\* All Footings are 12" Sono tube and are 2 ft deep

APPROVED  
Limited building only review  
Permit holder responsible for full compliance with the code

FRONT ELEVATION

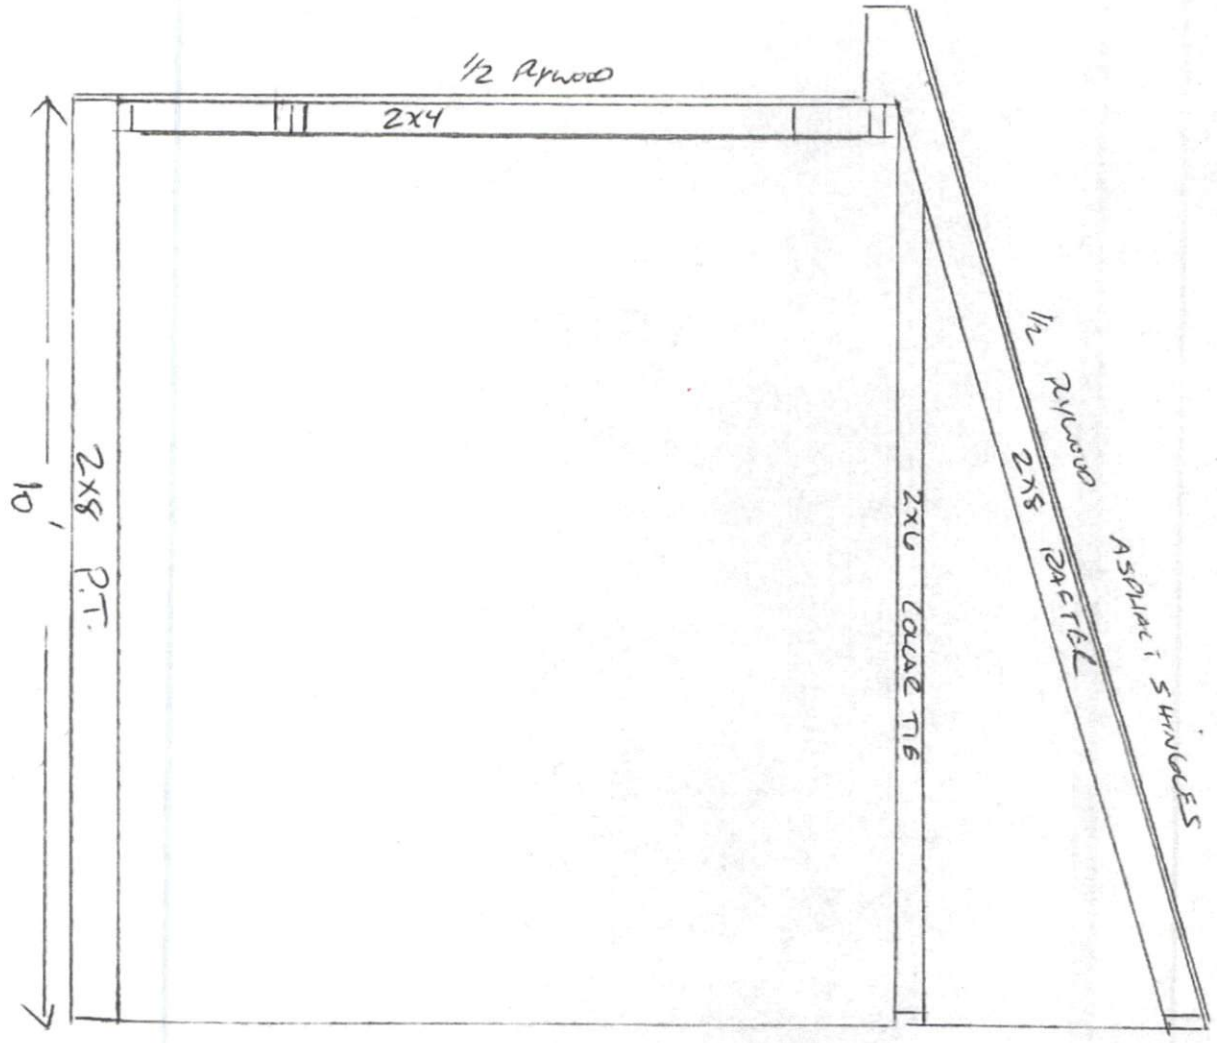
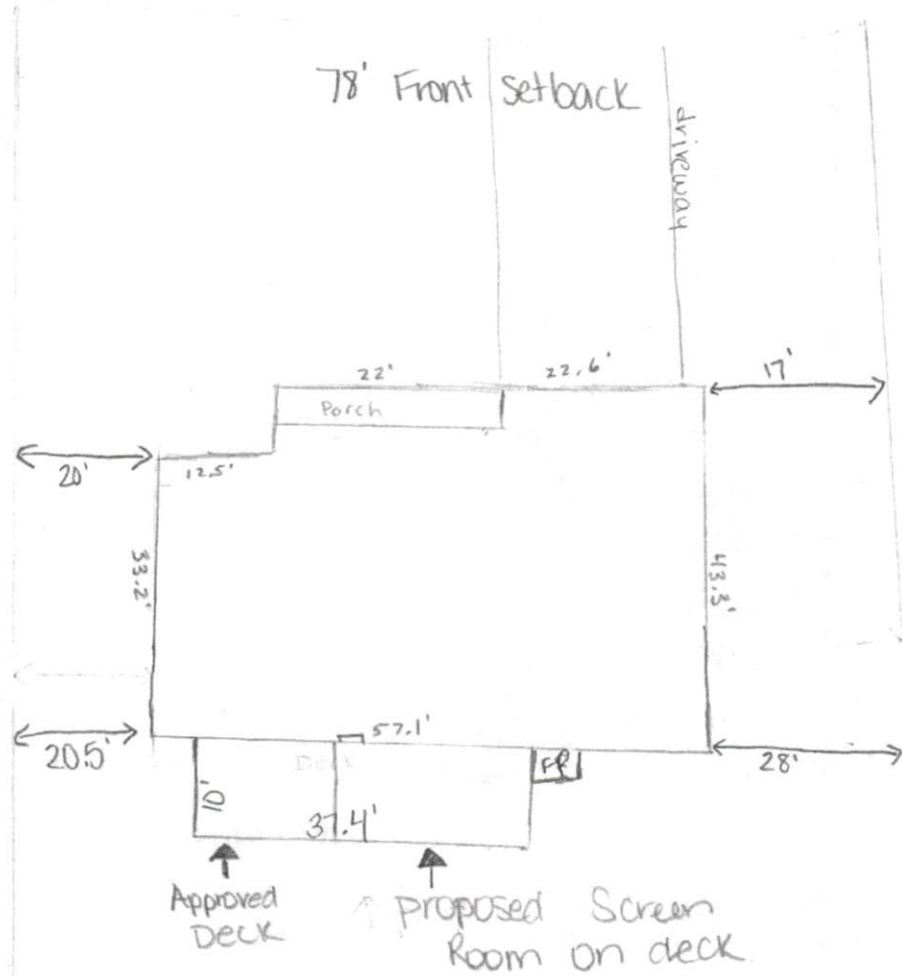
Per appendix "M" 2018 NCRC. Footings may not exceed 8' 6" spacing with 3-2x8 exterior girder. Footings must be 18 inches in diameter if round to meet equivalent area of footings required by NCRC2018. Footings must be minimum 12" below grade. Posts may not be supported on existing 4 inch slab.
